MEMORANDUM

DATE: February 7, 2022  
*(Galloway Response to 2<sup>nd</sup> Round Comments – 03/31/2022)*

SUBJECT: CDR-21-018 – Bent Grass / Woodmen Frontage Road Turn Lane  
Second Submittal

## STREET IMPROVEMENT SECTIONS

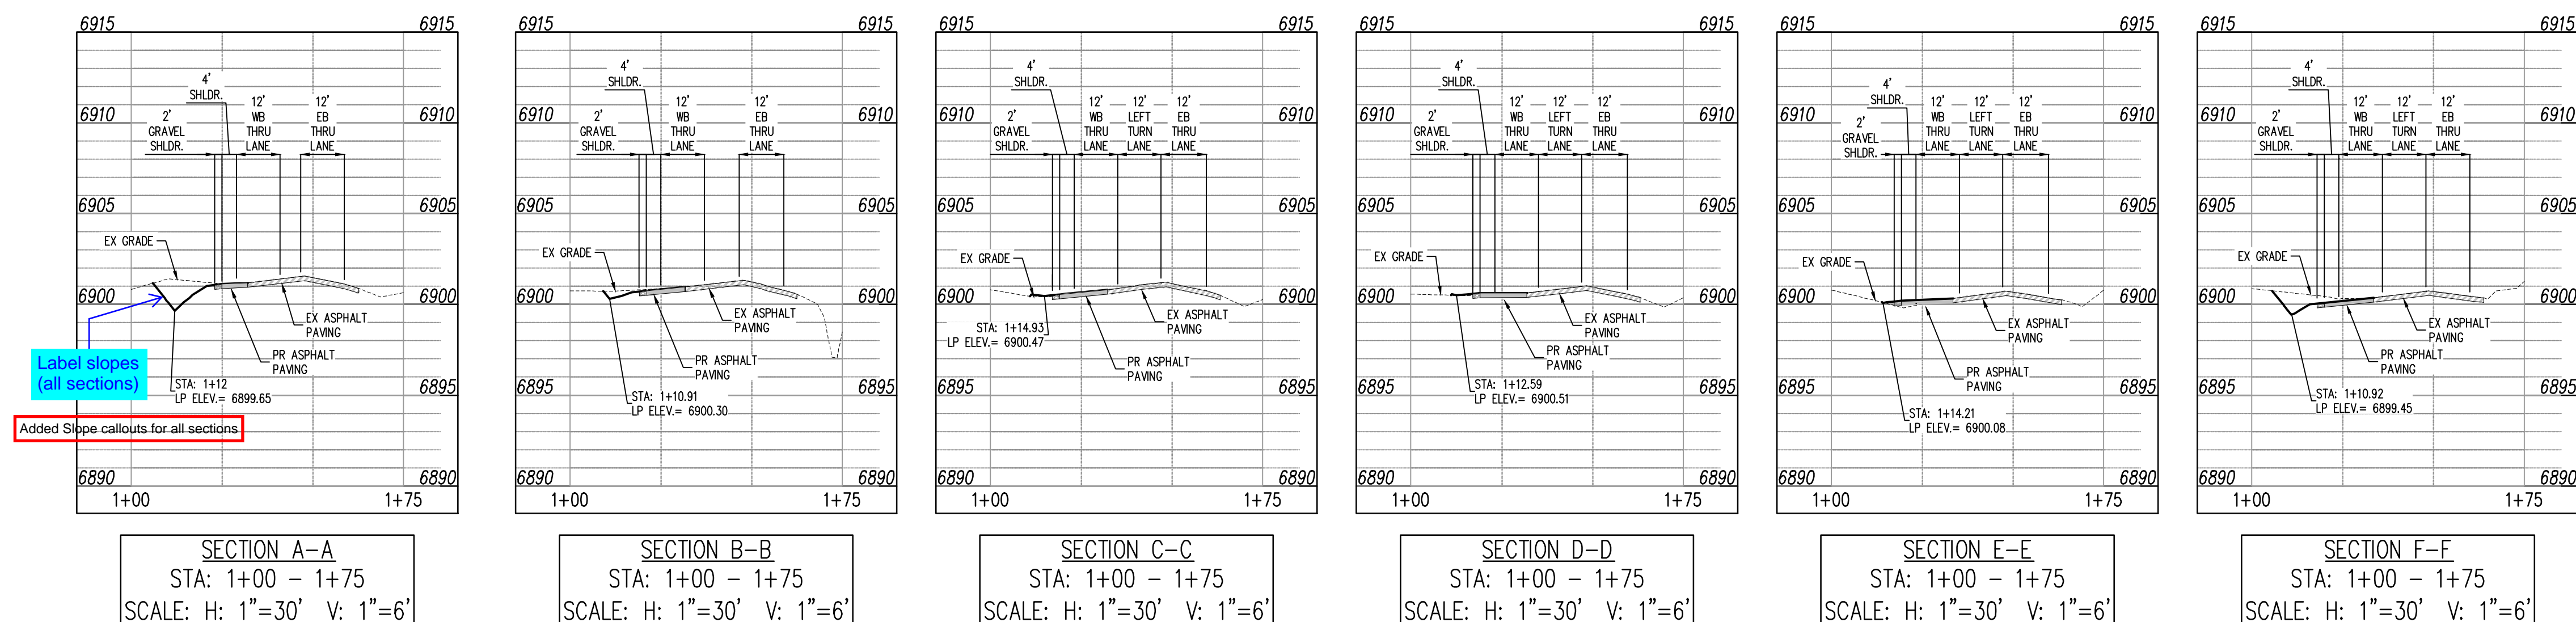
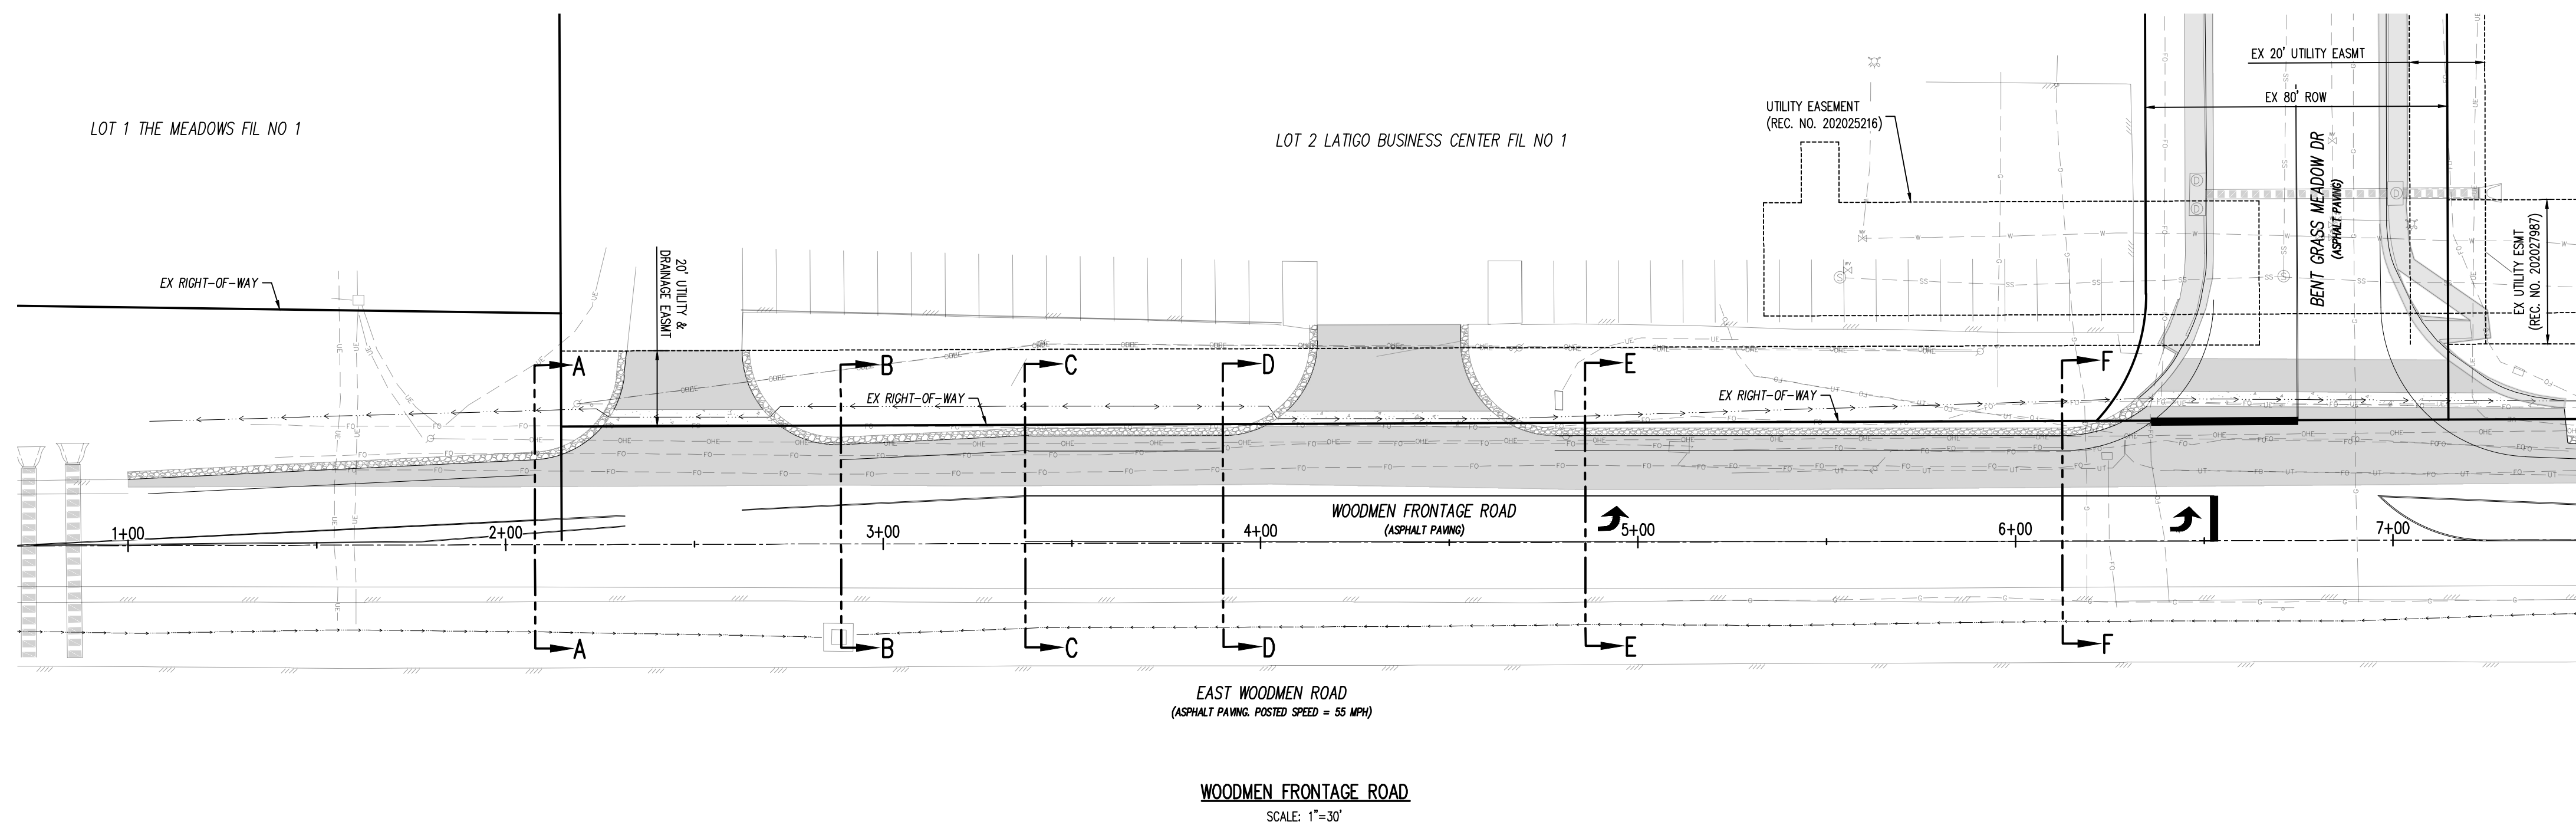
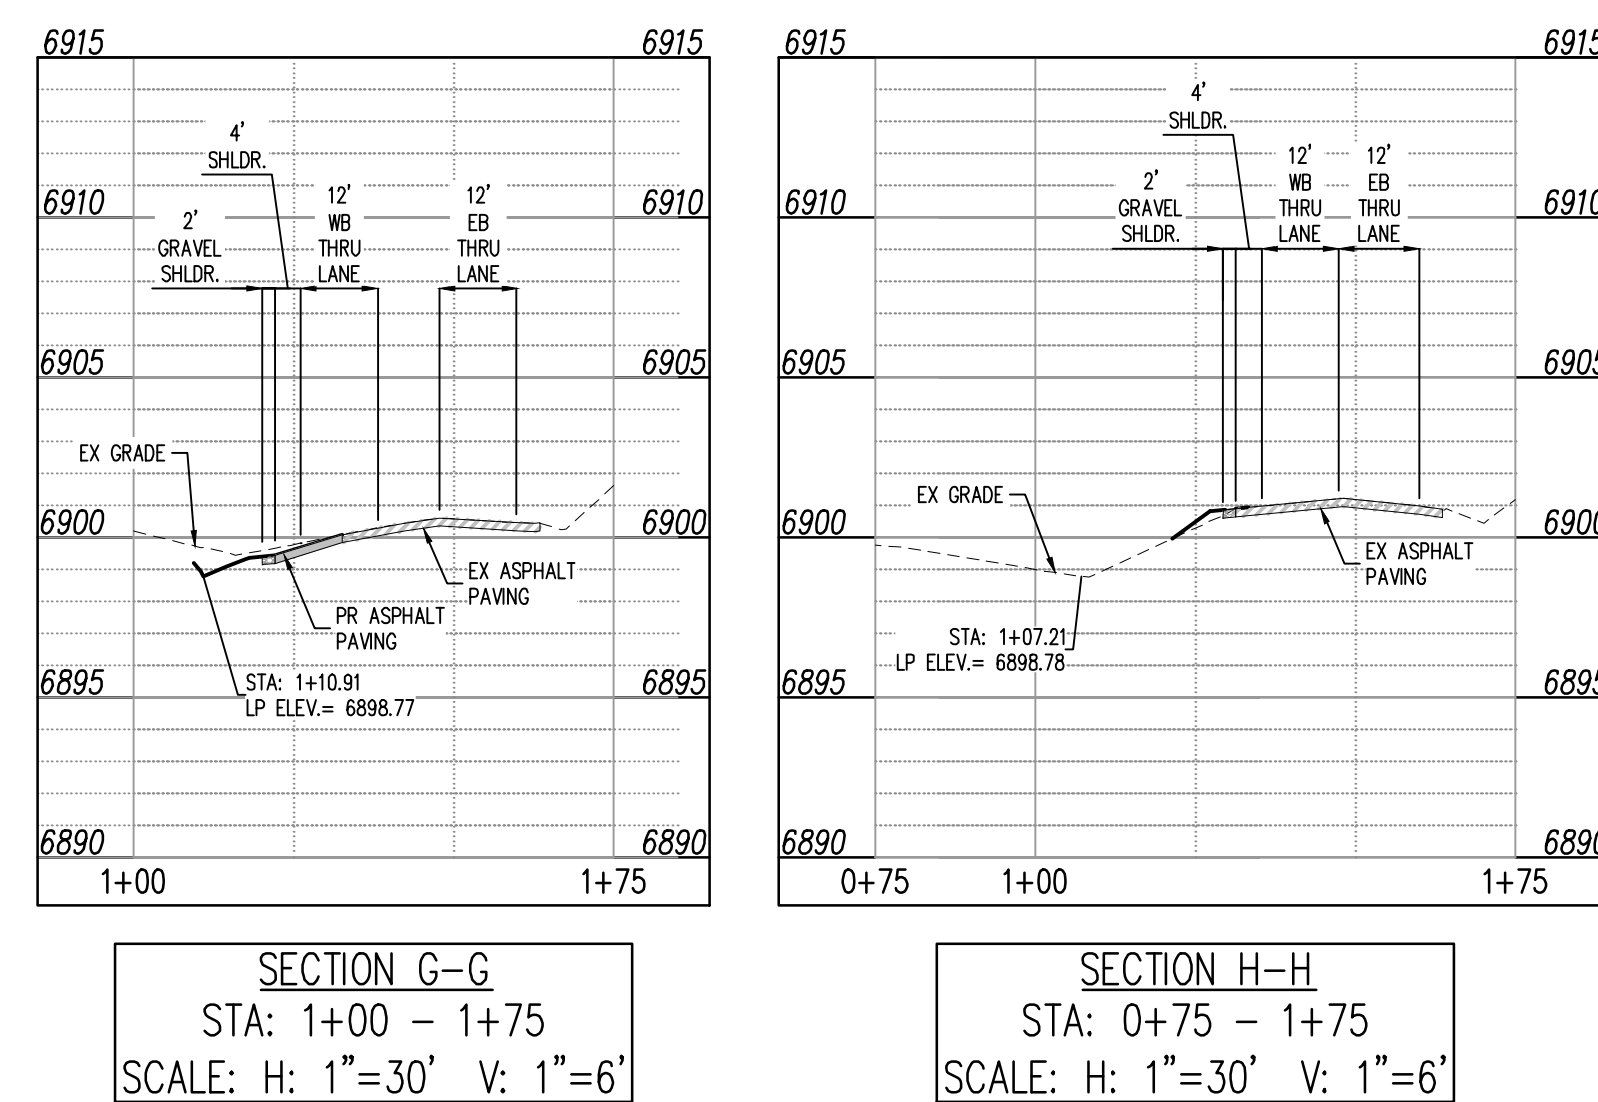
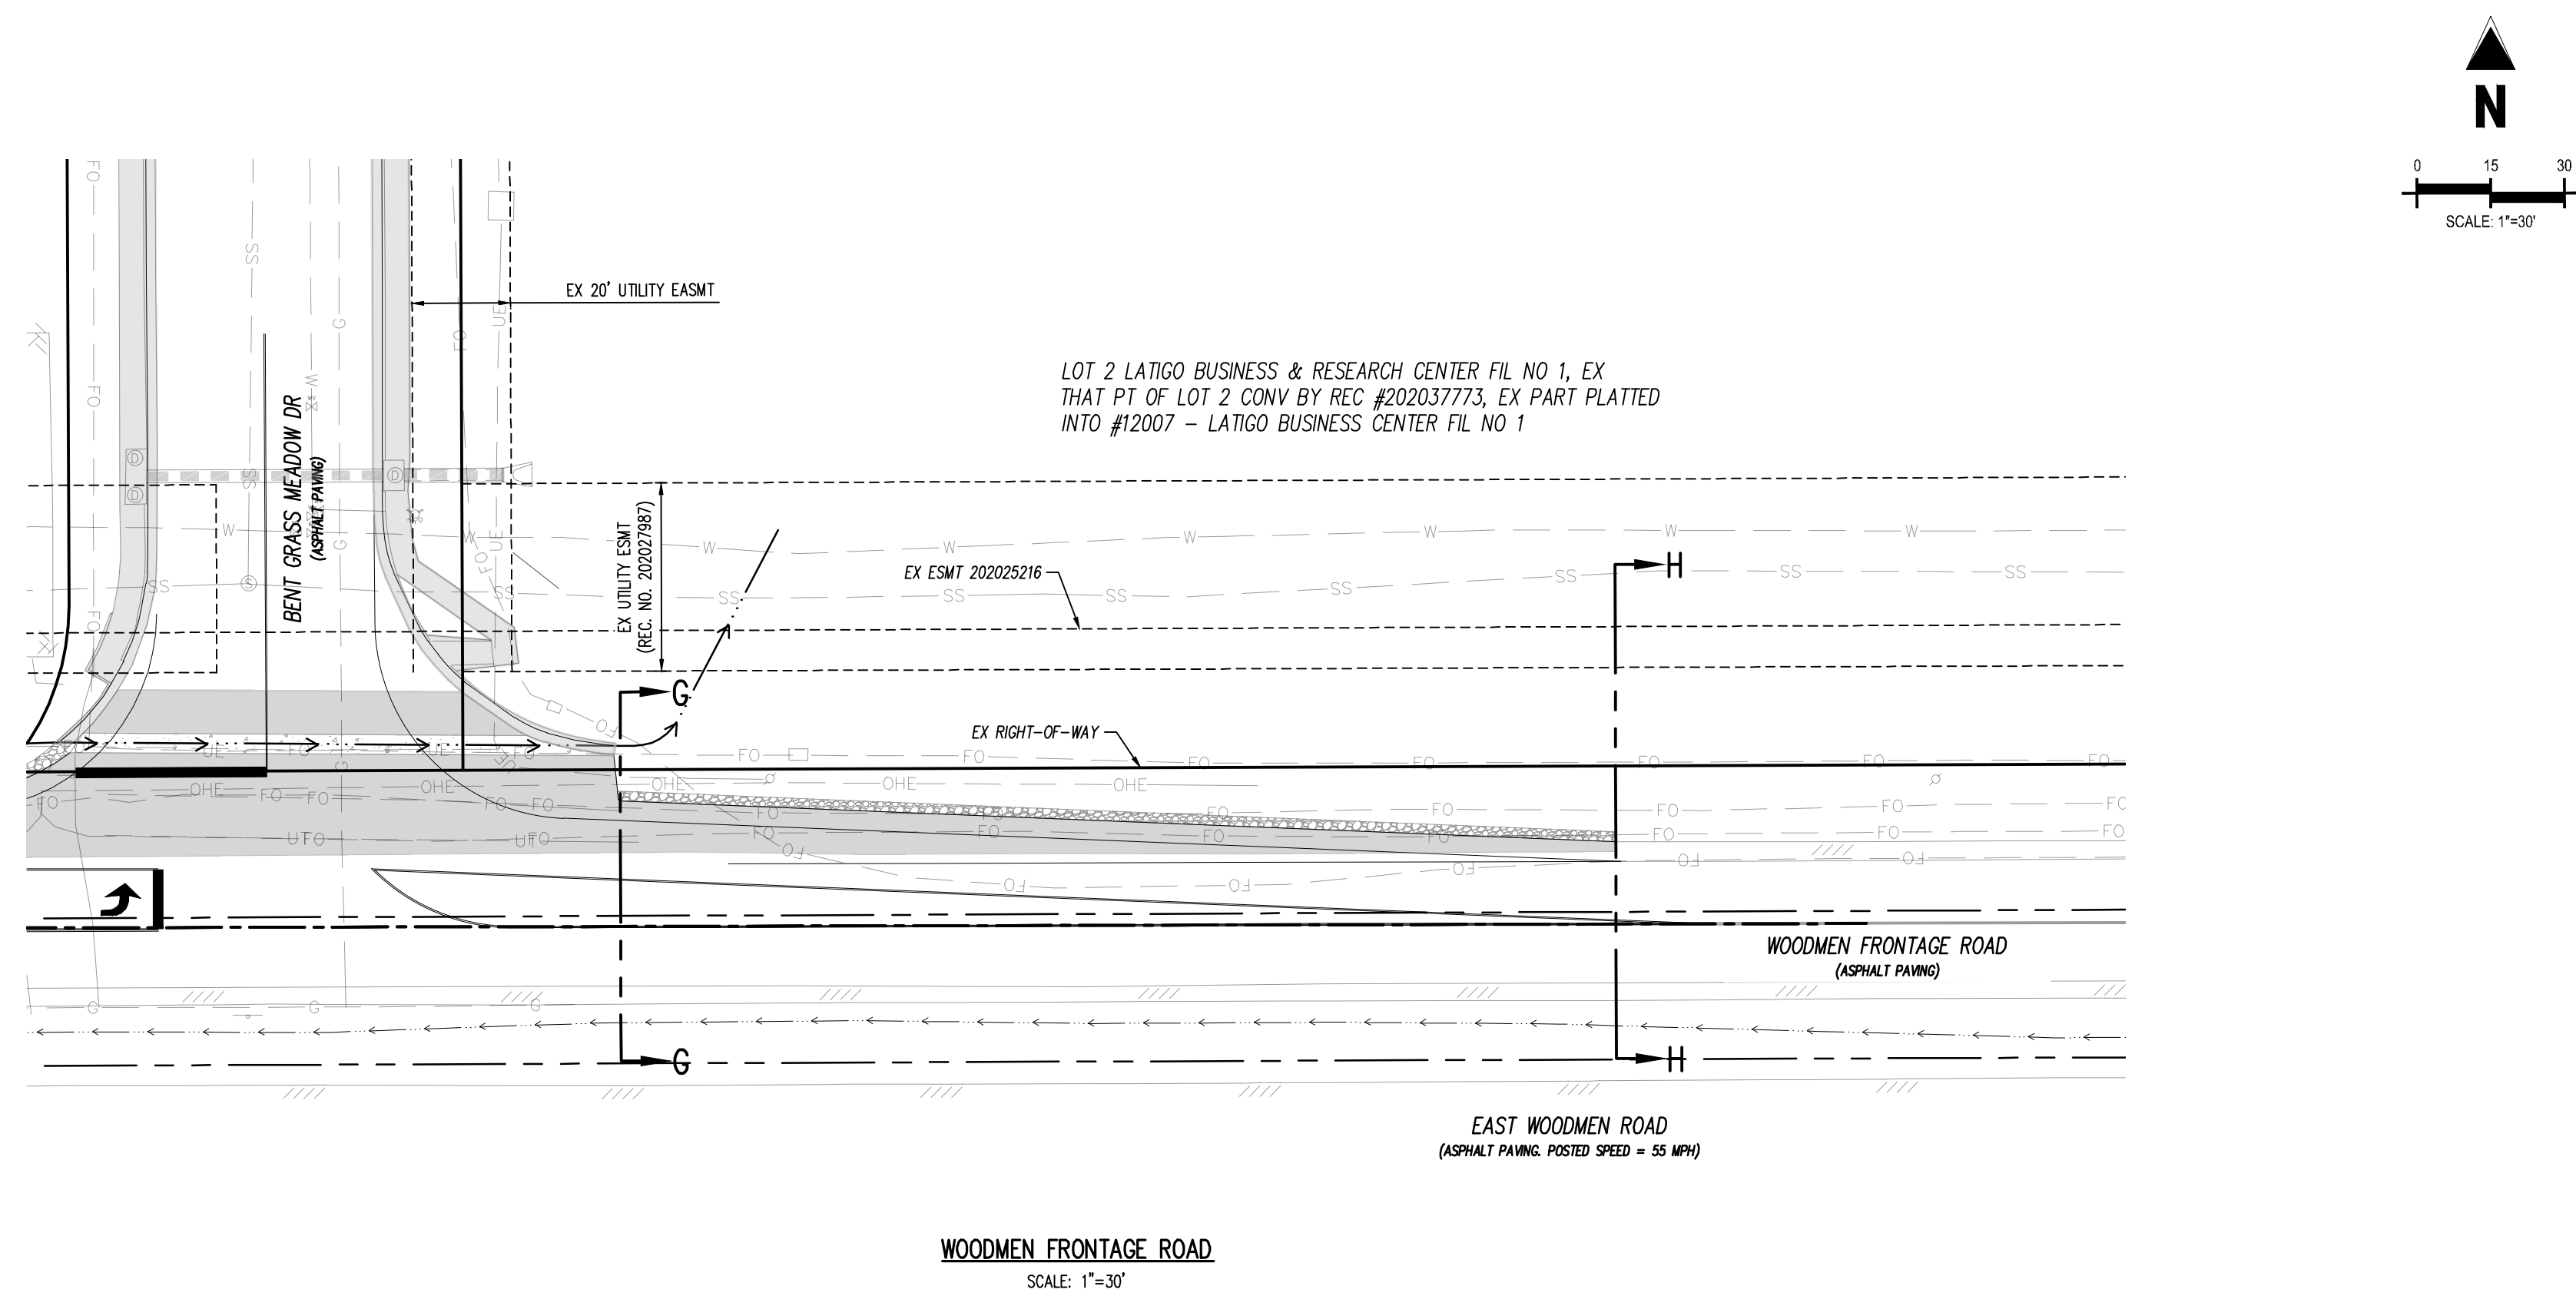
3. The roadside swales need to be shown to be adequate both in the drainage report calculations and the CD cross-sections.

***Response: Included roadside swale capacity calculations in the drainage report and CD cross-sections***
